# WILLOWTREE PLANNING

REF: WTJ21 - 285

**RE: RESPONSE TO SUBMISSIONS - PROPOSED SECTION 4.55(1A) MODIFICATION APPLICATION - SSD 9522 (MOD 2)**

**PROPERTY AT 657-769 MAMRE ROAD, KEMPS CREEK LOT 34 DP1118173, LOTS X & Y DP421633, LOT 1 DP 1018318 & LOT 22 DP258414)**

SUBDIVISION
PLAN – STAGE 1

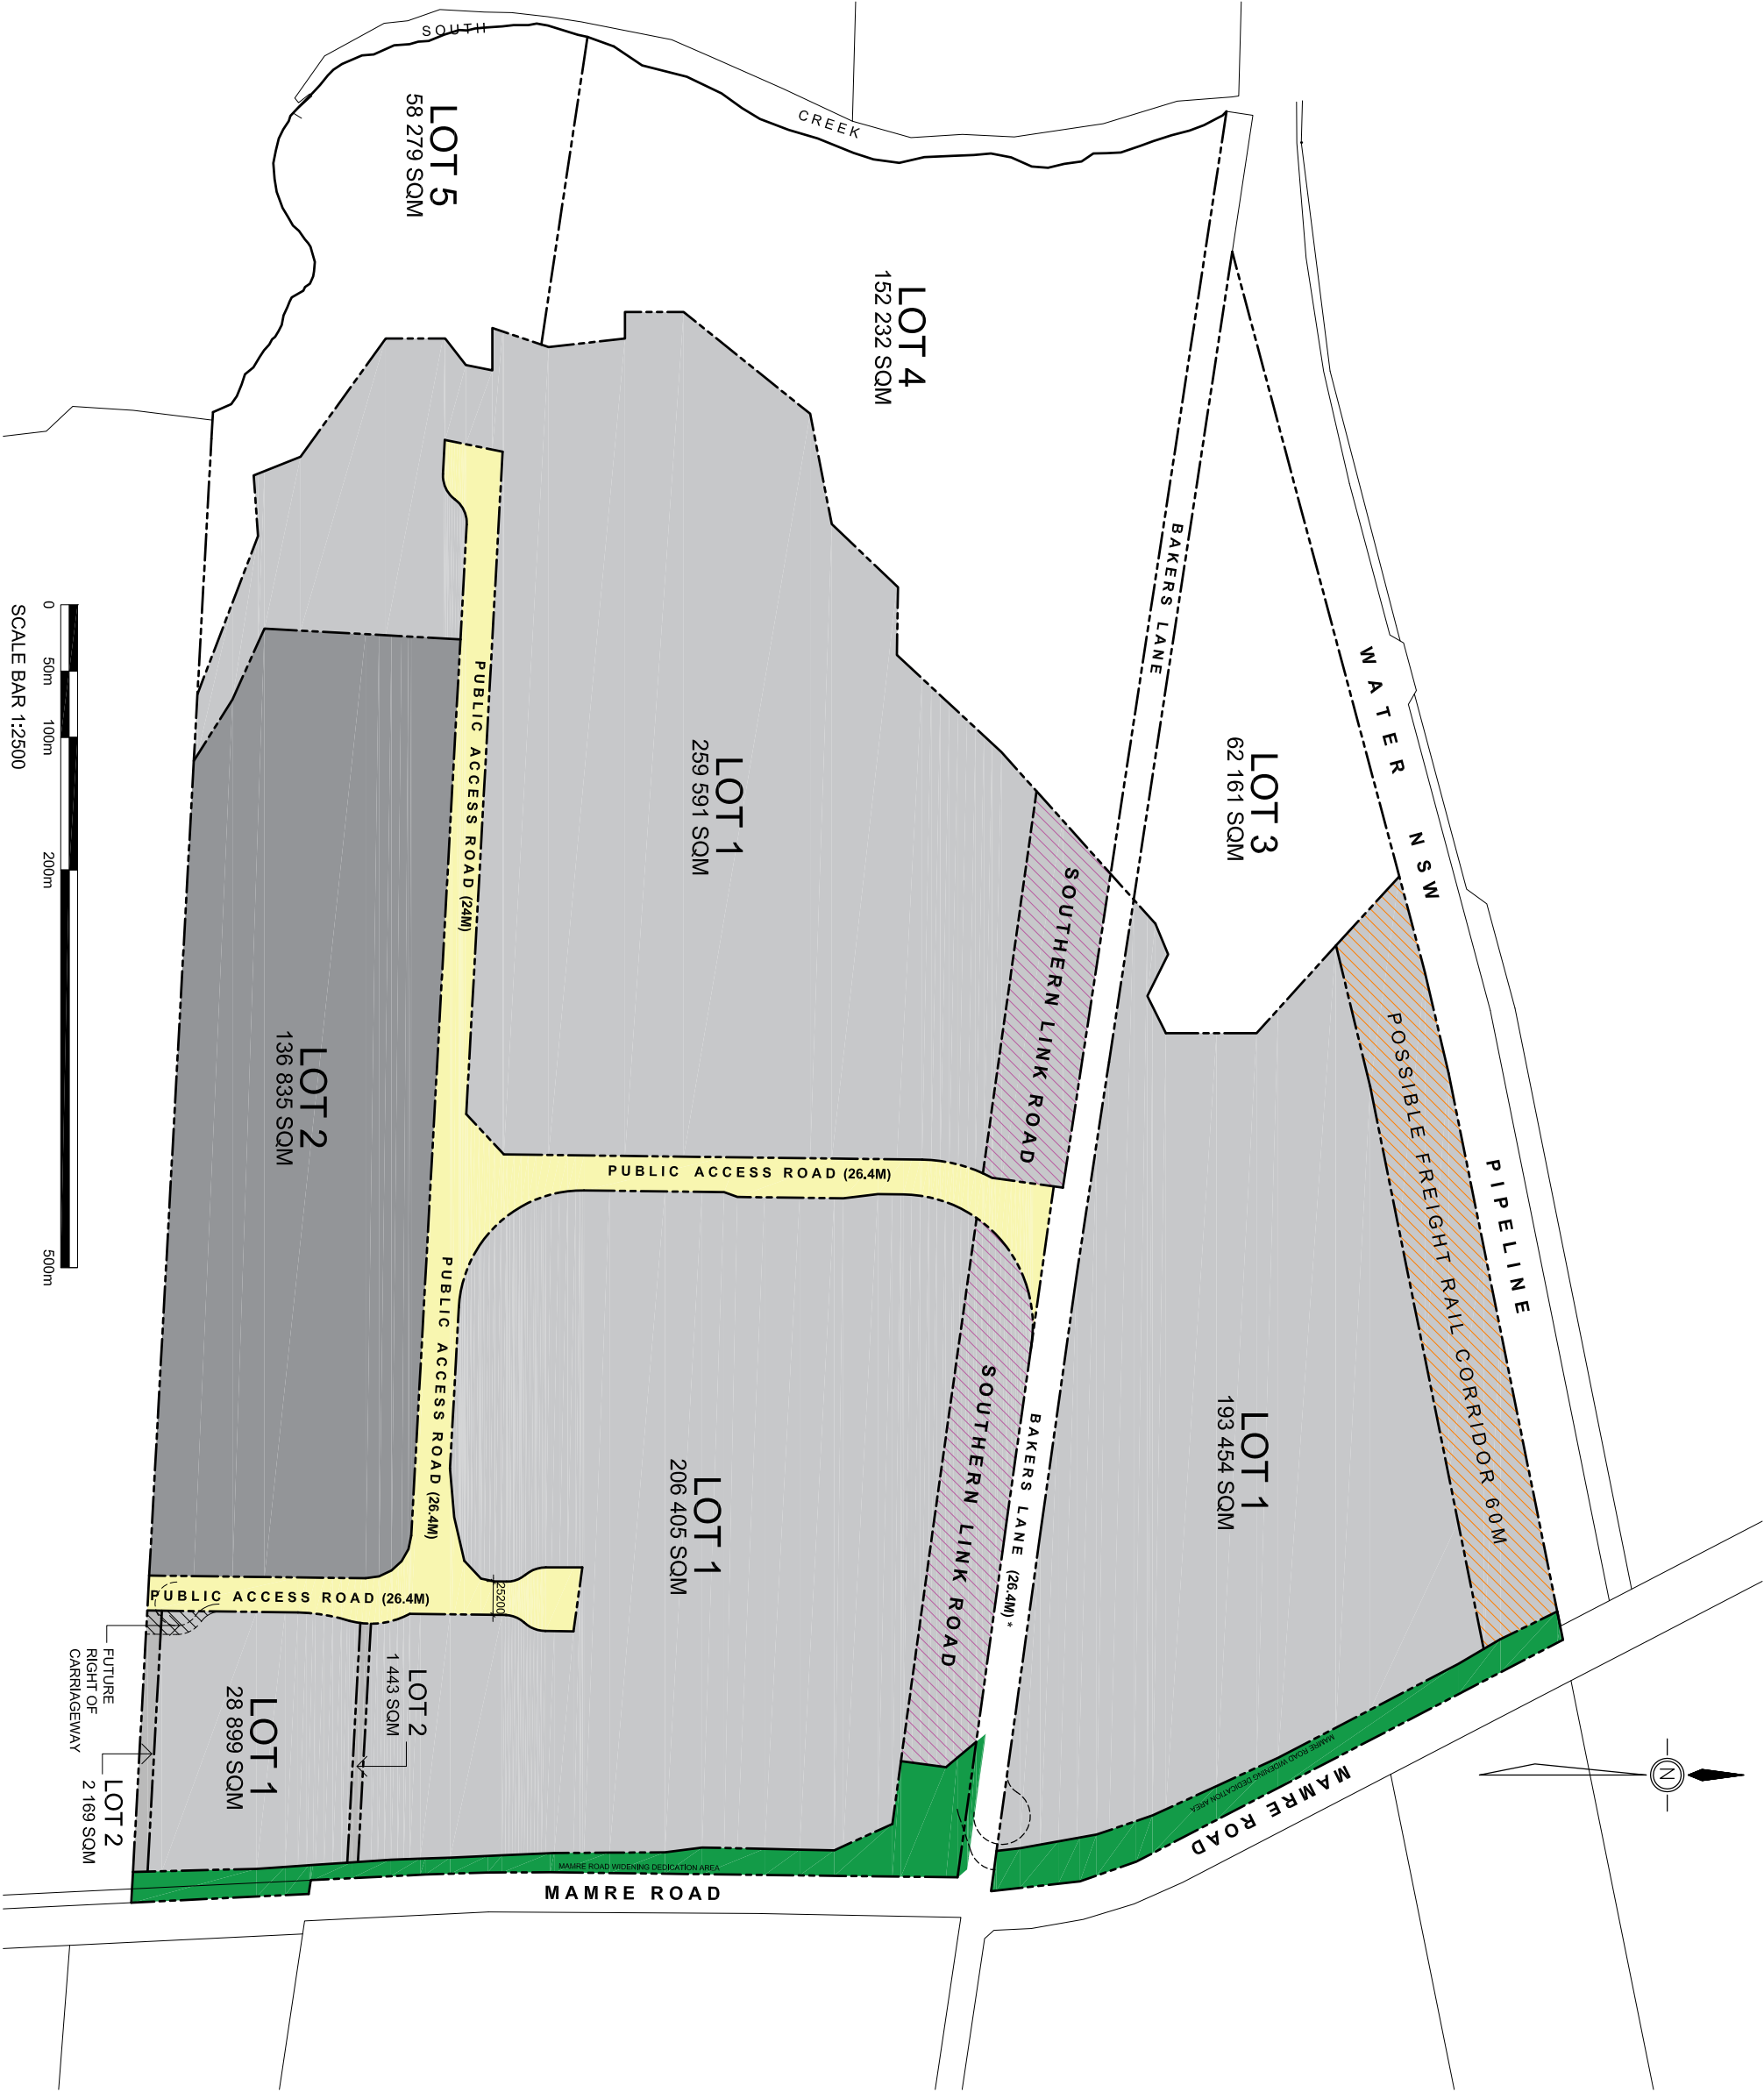
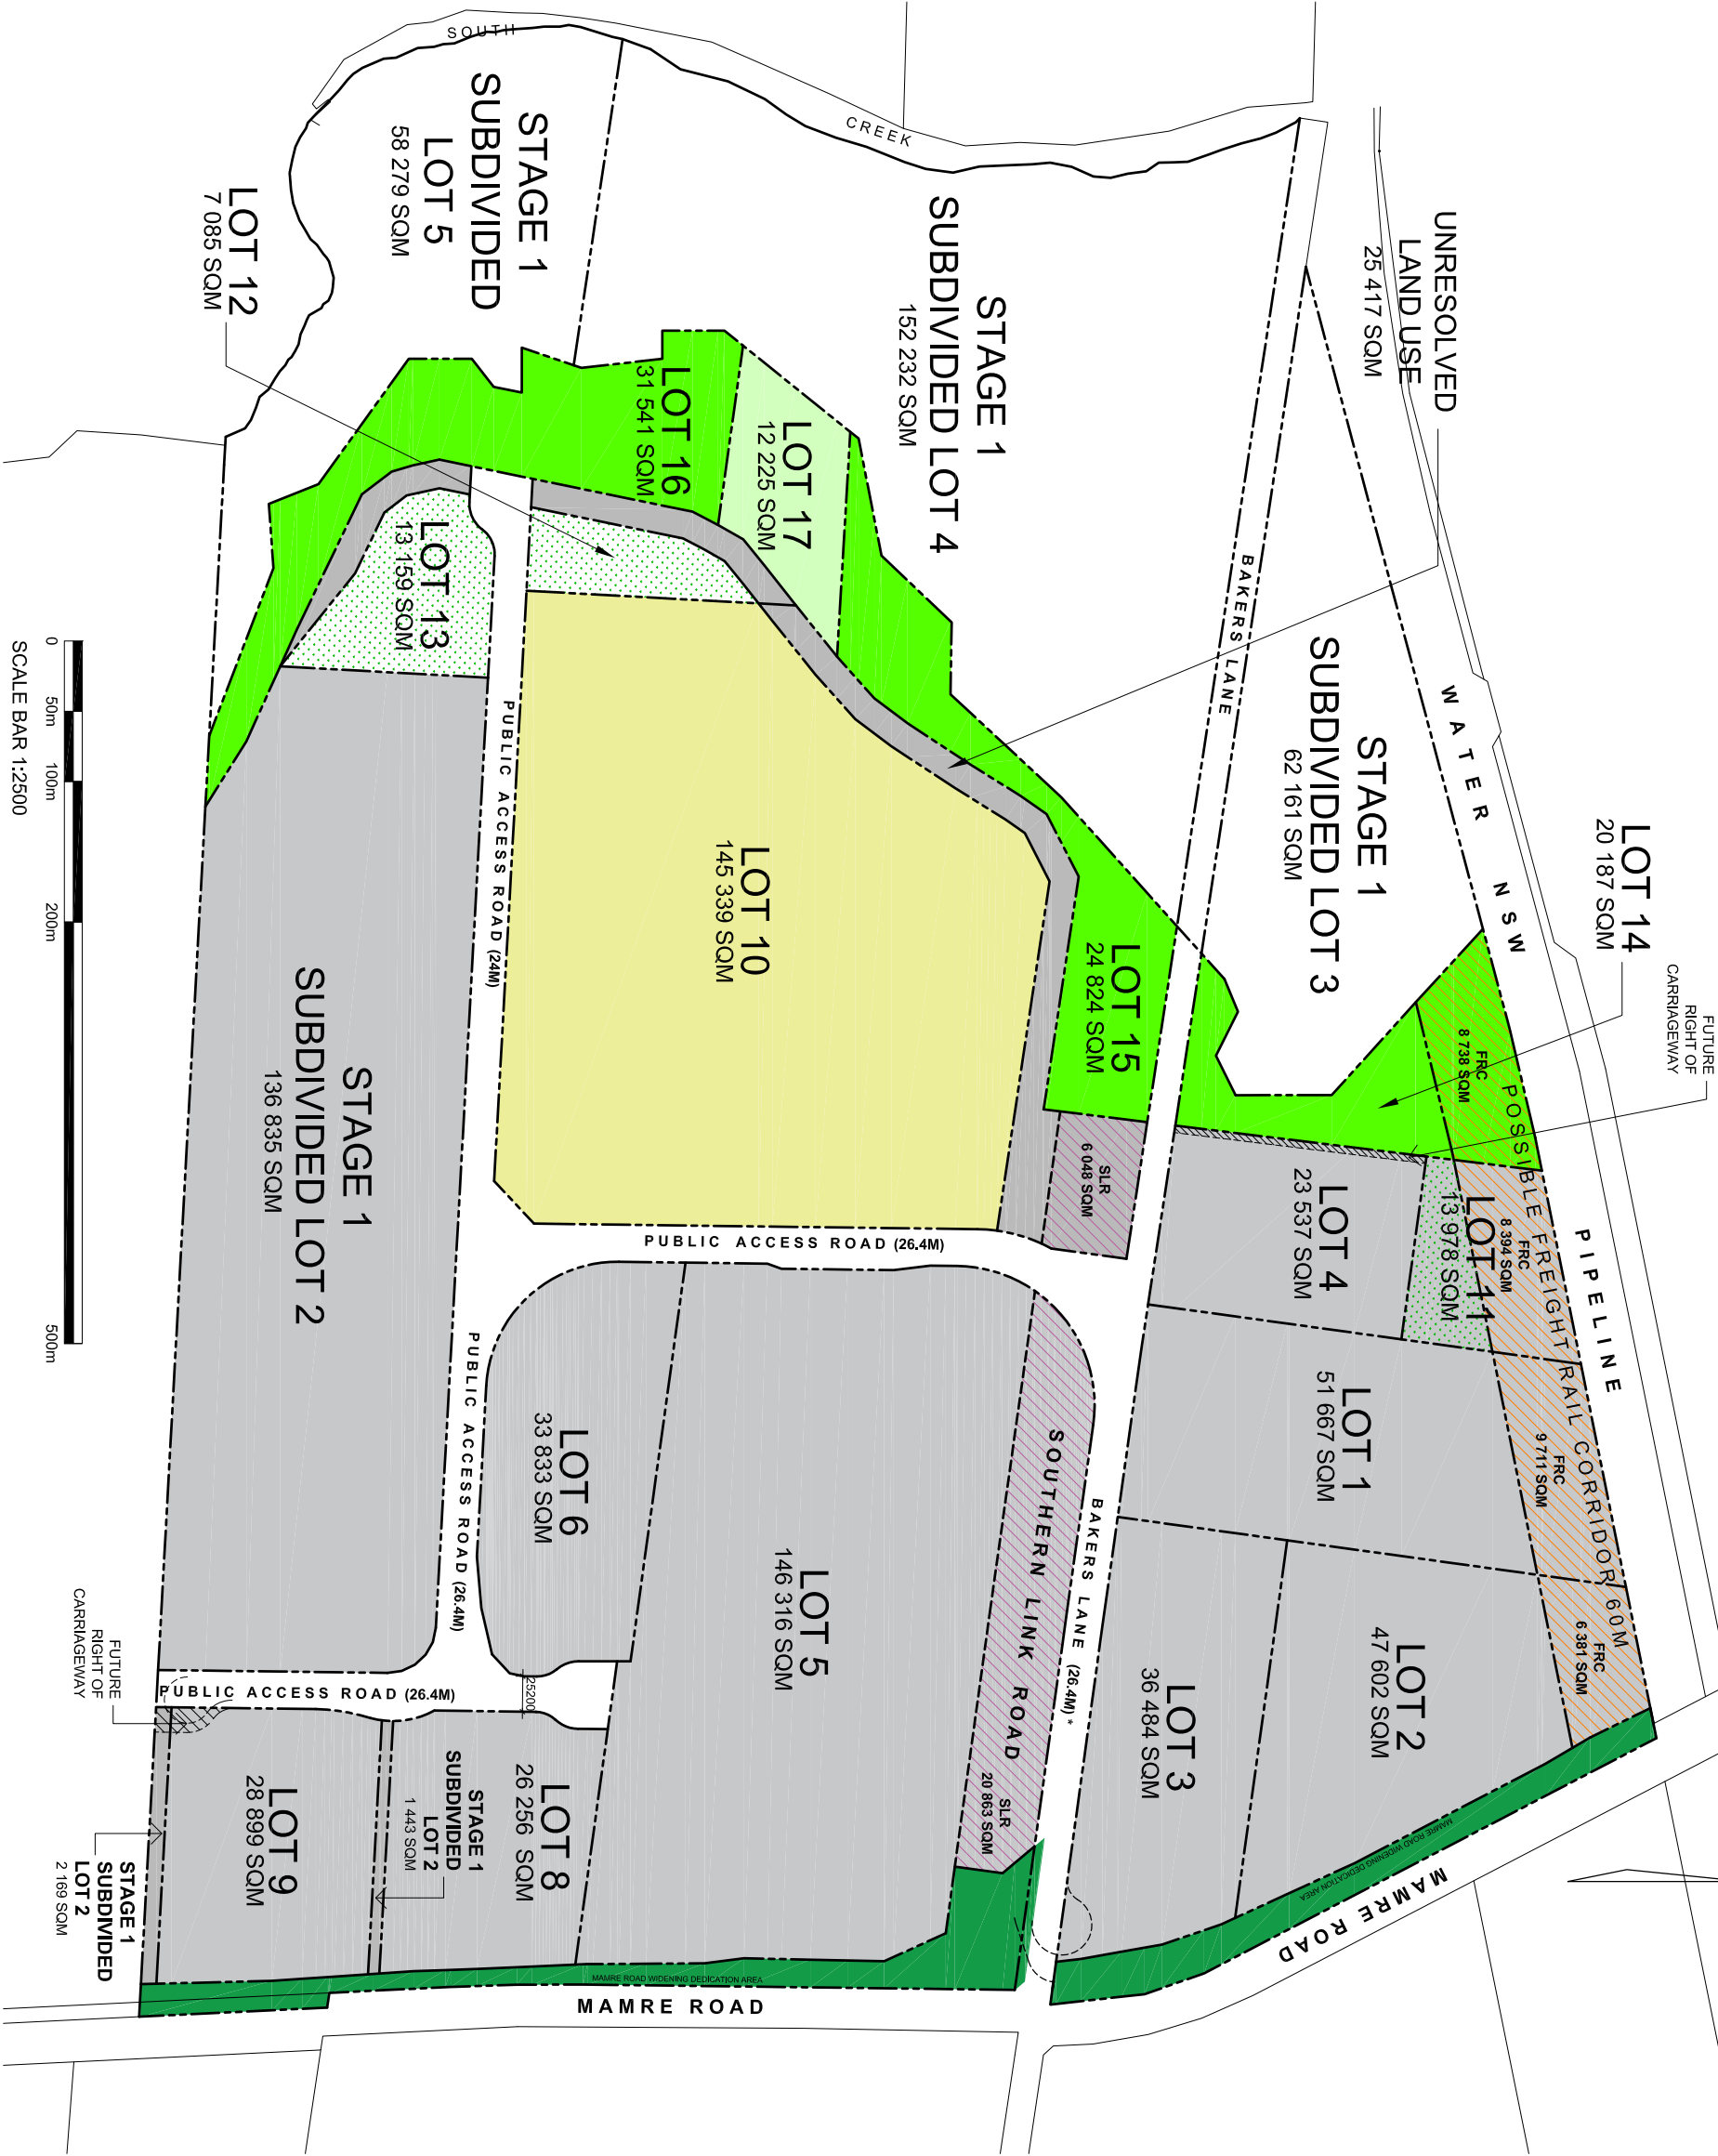
In addition, this letter seeks to amend Condition A26 of SSD 9522 pursuant to Clause 121B of the *Environmental Planning and Assessment Regulation 2000* to modify the boundary alignment of the lot to a line of best fit given the irregularity of the *State Environmental Planning Policy (Western Sydney Employment Area) 2009* (WSEA SEPP) zoning boundaries. Updated plans have been provided in **Appendix 1** which include the proposed lot boundary. Specifically, Condition A26 is proposed to be amended to read as follows:

*Prior to the issue of the subdivision certificate required under condition A25, the applicant must demonstrate the lot boundaries align with the current zoning under the State Environmental Planning Policy (Western Sydney Employment Area) 2009 to the satisfaction of the Planning Secretary.*

It is noted that there is no change in area between the RE1 and RE2 zoned land as a result of the proposed modification. Despite the relocation of approximately 2,141m<sup>2</sup> of land, the balance of the land remains unchanged as reflected on the plans provided in **Appendix 1**.
